Subject: Sanderling Avenue Residential Flat Buildings Environmental Impact Statement (SSD-82066472) (Mid-Coast)

Attachment 1: Detailed Comments for Sanderling Avenue Residential Flat Buildings Environmental Impact Statement (SSD-82066472)

HAWKS NEST RESIDENTIAL DEVELOPMENT : SITE PLAN

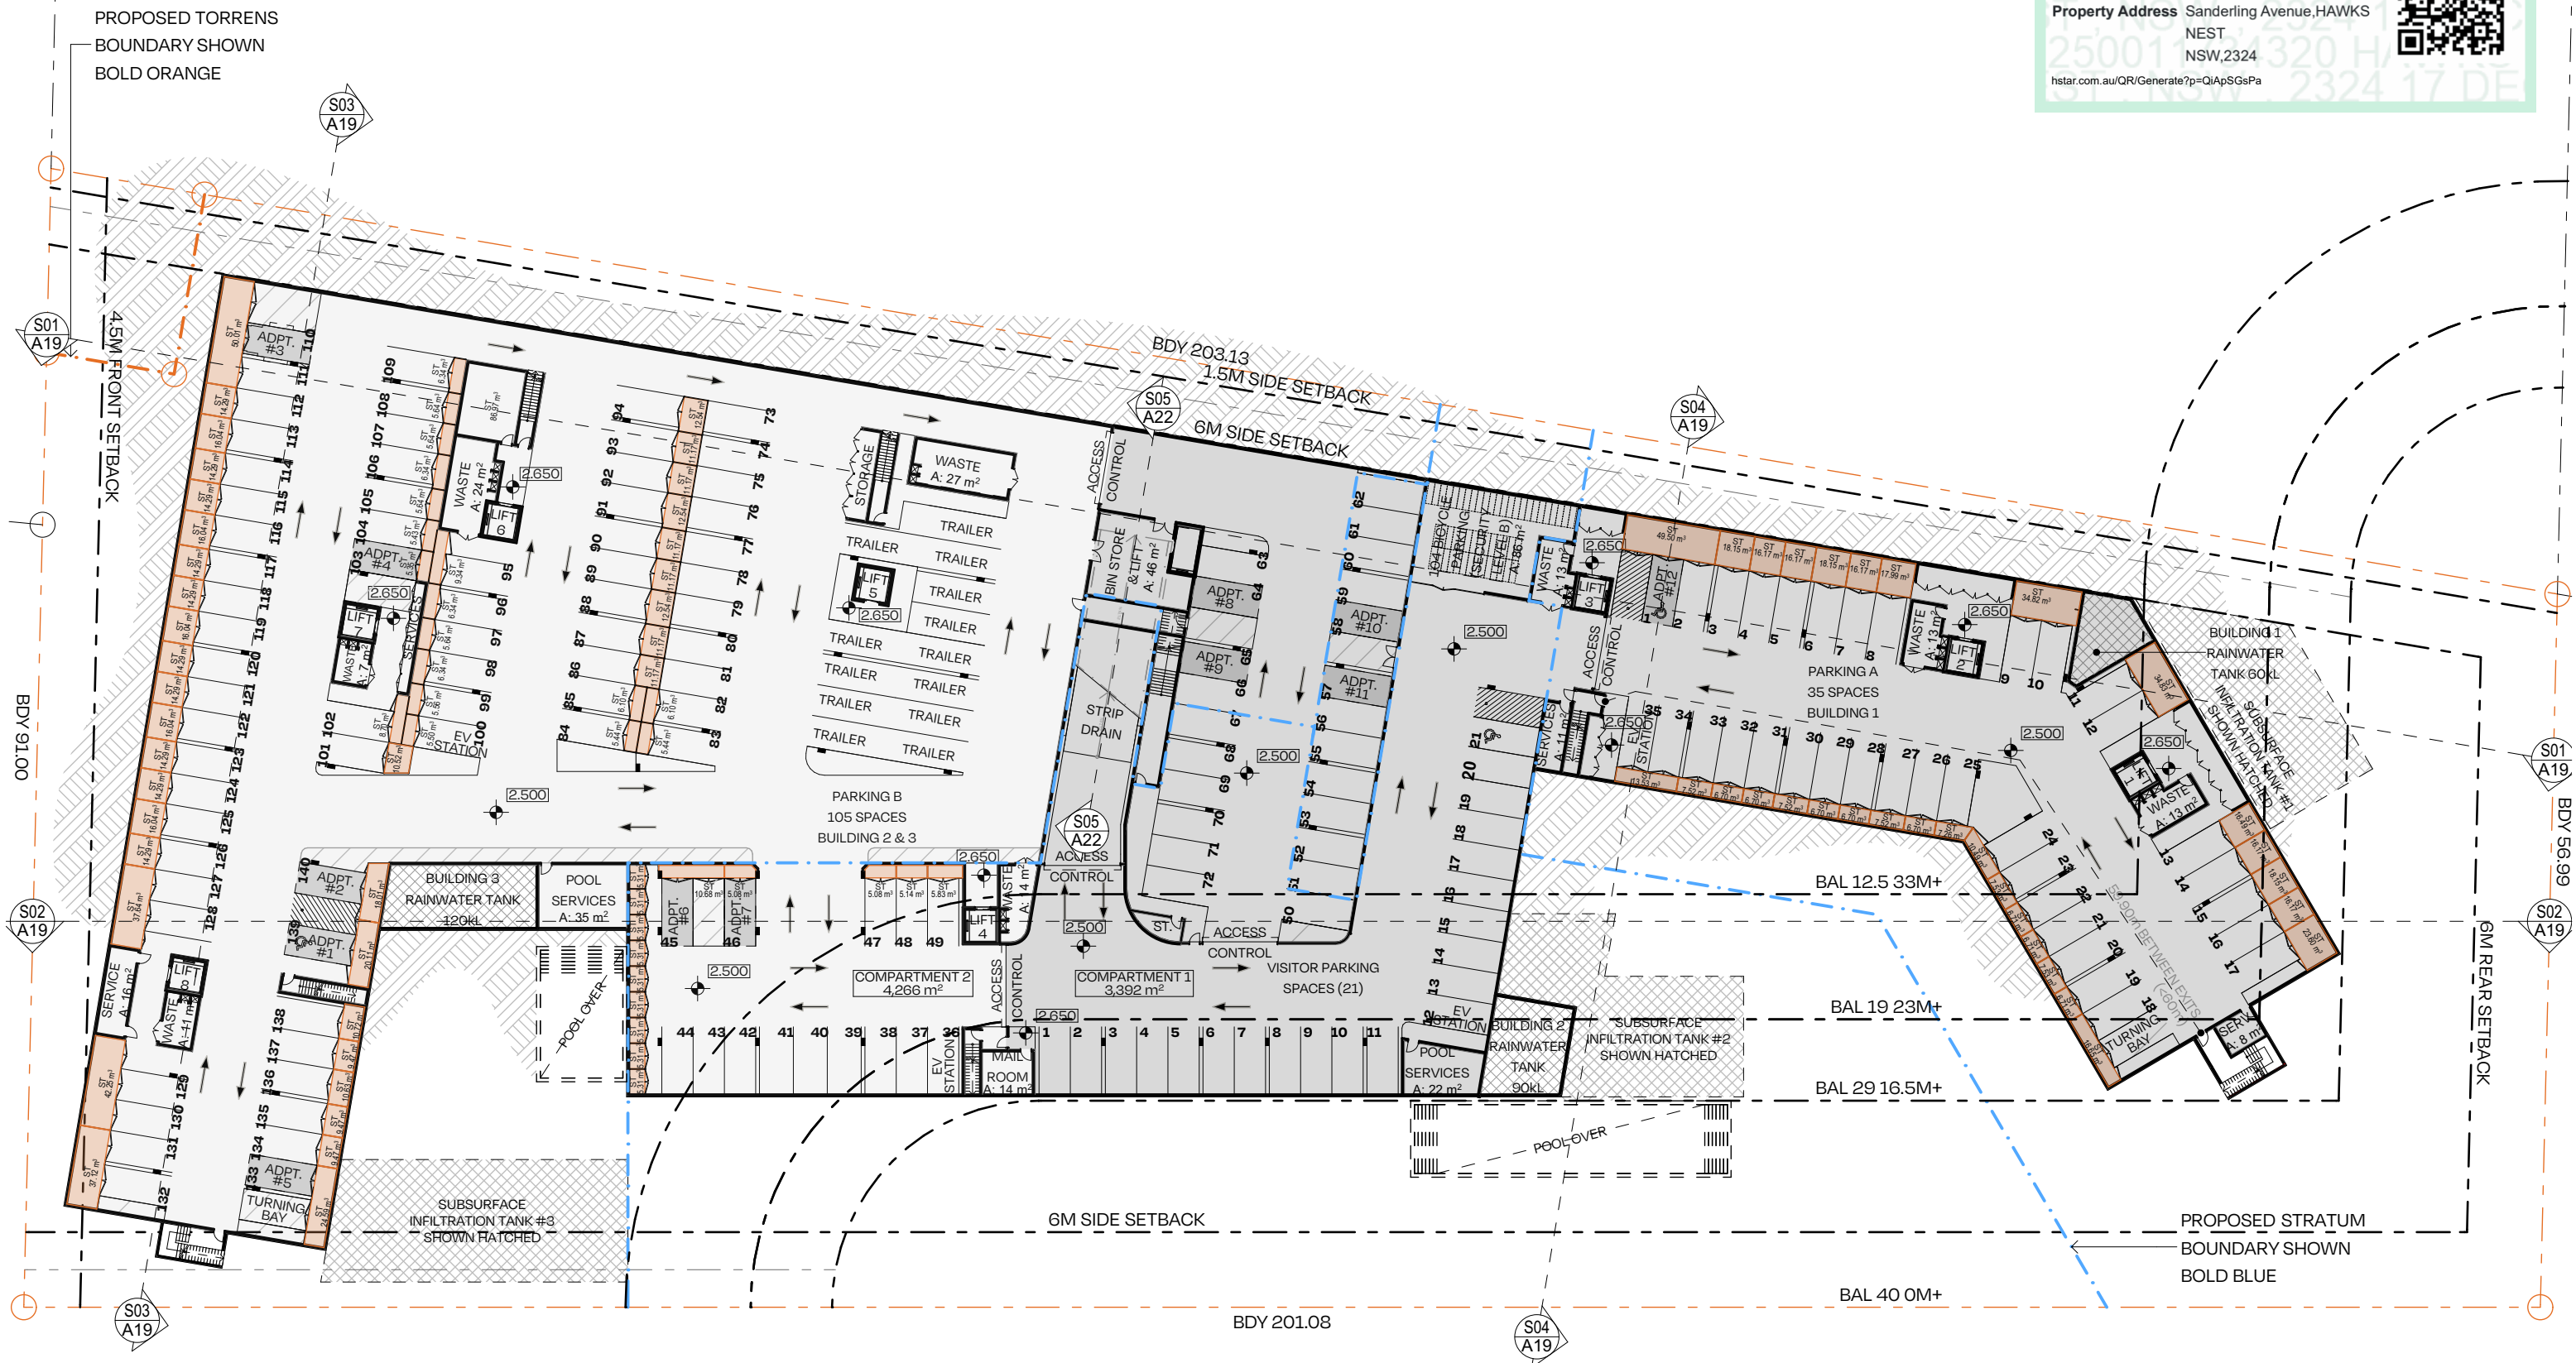
The BDAR's description of the proposal's location is not consistent with figures within the BDAR nor the EIS. The BDAR describes the proposal's location as the entirety of Lot 1 DP 1234229. However, the BDAR figures show portions of the development footprint that extends beyond this Lot to the west and south. These areas extending outside the Lot are irregular in shape and it is unclear to CPHR what parts of the proposed development they represent. Notably, these extended areas impact upon some of the higher condition vegetation and habitat.

In addition, the EIS describes the proposal as including three components: the residential flat buildings, the golf club site and the road upgrade. However, the BDAR has only assessed impacts for the residential flat buildings. No explanation has been provided on why the other development components have not been included.

The proposal does not demonstrate reasonable measures to avoid or minimise biodiversity impacts, impacting the entire lot and additional areas outside the lot containing good condition vegetation. The parts of the study area shown in the BDAR as being avoided are outside of the subject lot, zoned RE1 and the ownership of these areas is unclear. Evidence should be provided that the design has been made or altered to avoid areas of higher condition vegetation and threatened species habitat and/or to prioritise impacts within lower condition vegetation, cleared and/or exotic areas.

2. Clarify the nature and extent of the proposal and ensure this is consistent between all assessment documents within the EIS.
3. Ensure that all development components required for the proposal have been fully assessed in the BDAR

9. The BDAR be revised to include a complete assessment of avoiding or minimising impacts on biodiversity values in accordance with Chapter 7 of the BAM.
10. Where further avoidance or minimisation is practicable, the proposed design be revised accordingly and changes documented in the BDAR.
11. Where avoidance or minimisation is demonstrated to be not feasible, provide clear evidence-based rationale (e.g. technical, safety, economic, or operational constraints) to justify the residual impact footprint.
